Application No: AW/1/25/HH
Site Address: 27 Aldwick Avenue Aldwick PO21 3AQ
Description of works: Part single, part two storey side and rear extensions, conversion of garage to habitable use, hip to mansard roof extension with dormers, and alterations to fenestrations.

Thank you for your internet representation made on 6th February 2025 which has been recorded as an objection with the comments as follows:

Proposed parking

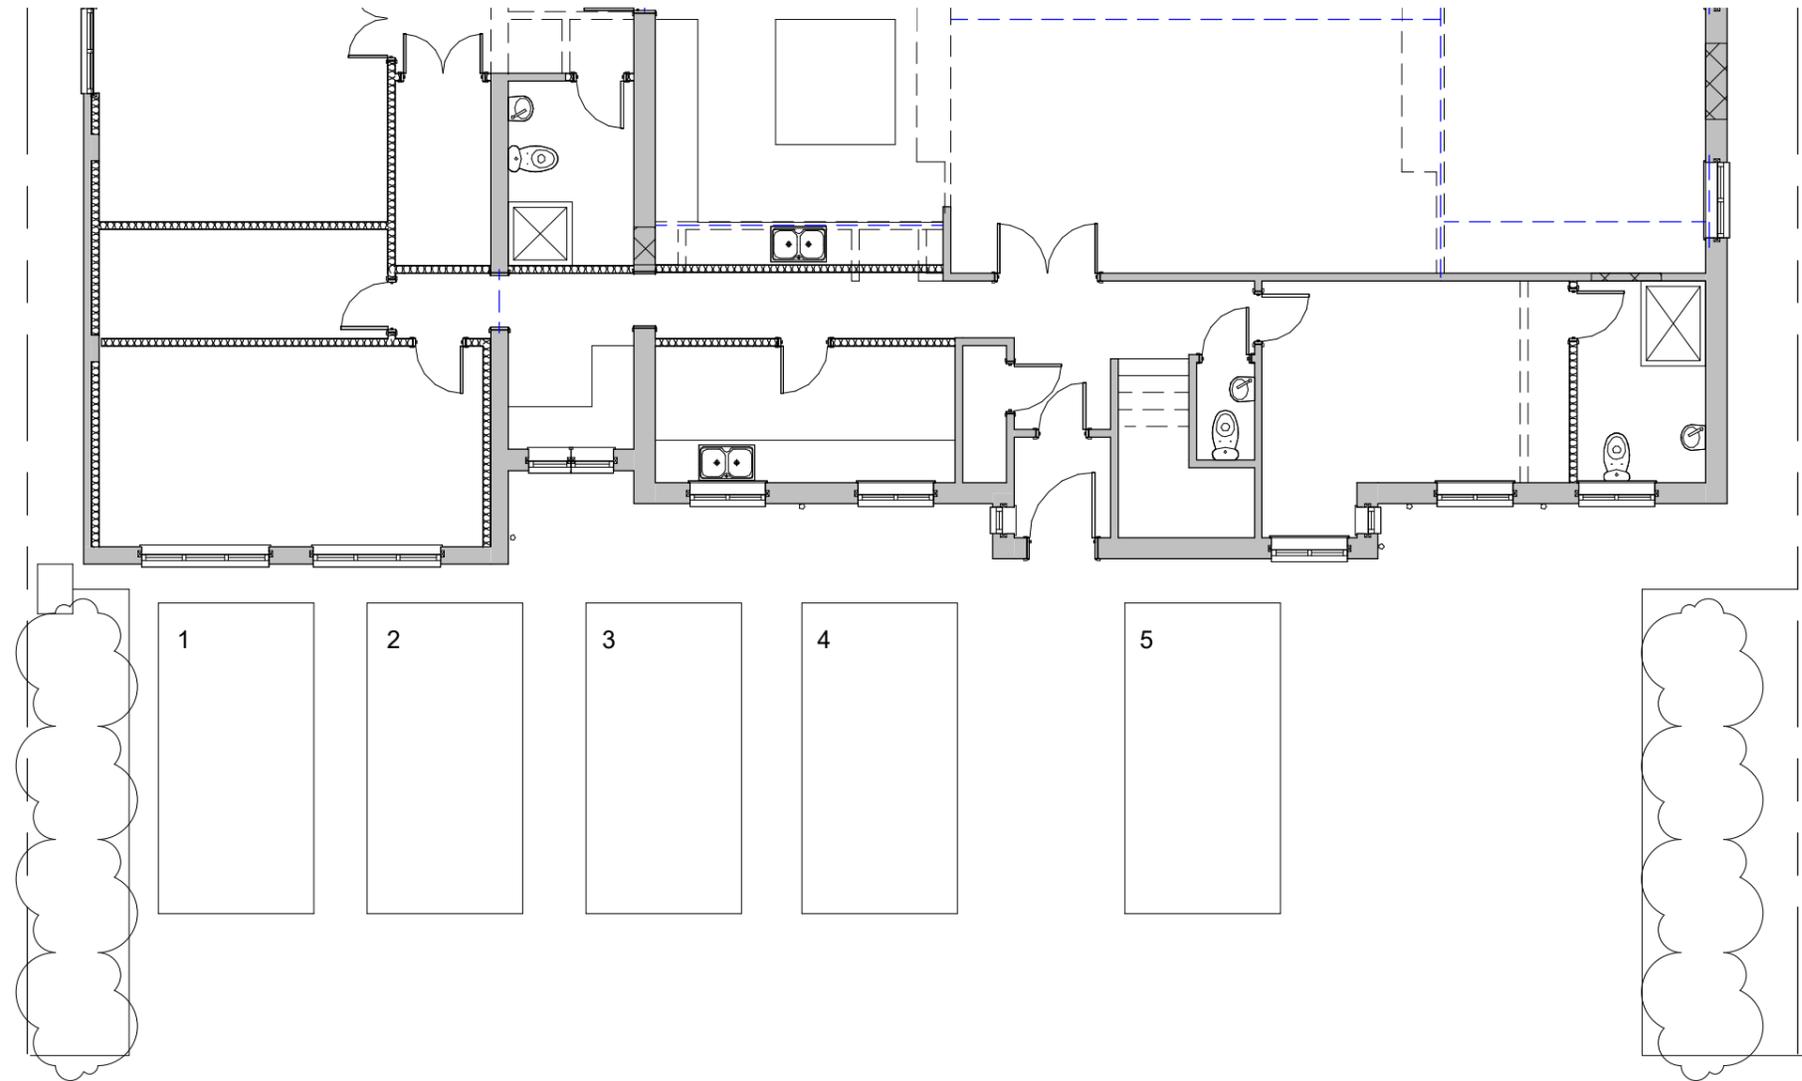
The plans wants to convert the garage into accommodation this will create limited parking on the property. As outside of this property there is a number car parked there already I believe this will cause a problem as there is limited amount of parking in the Avenue.
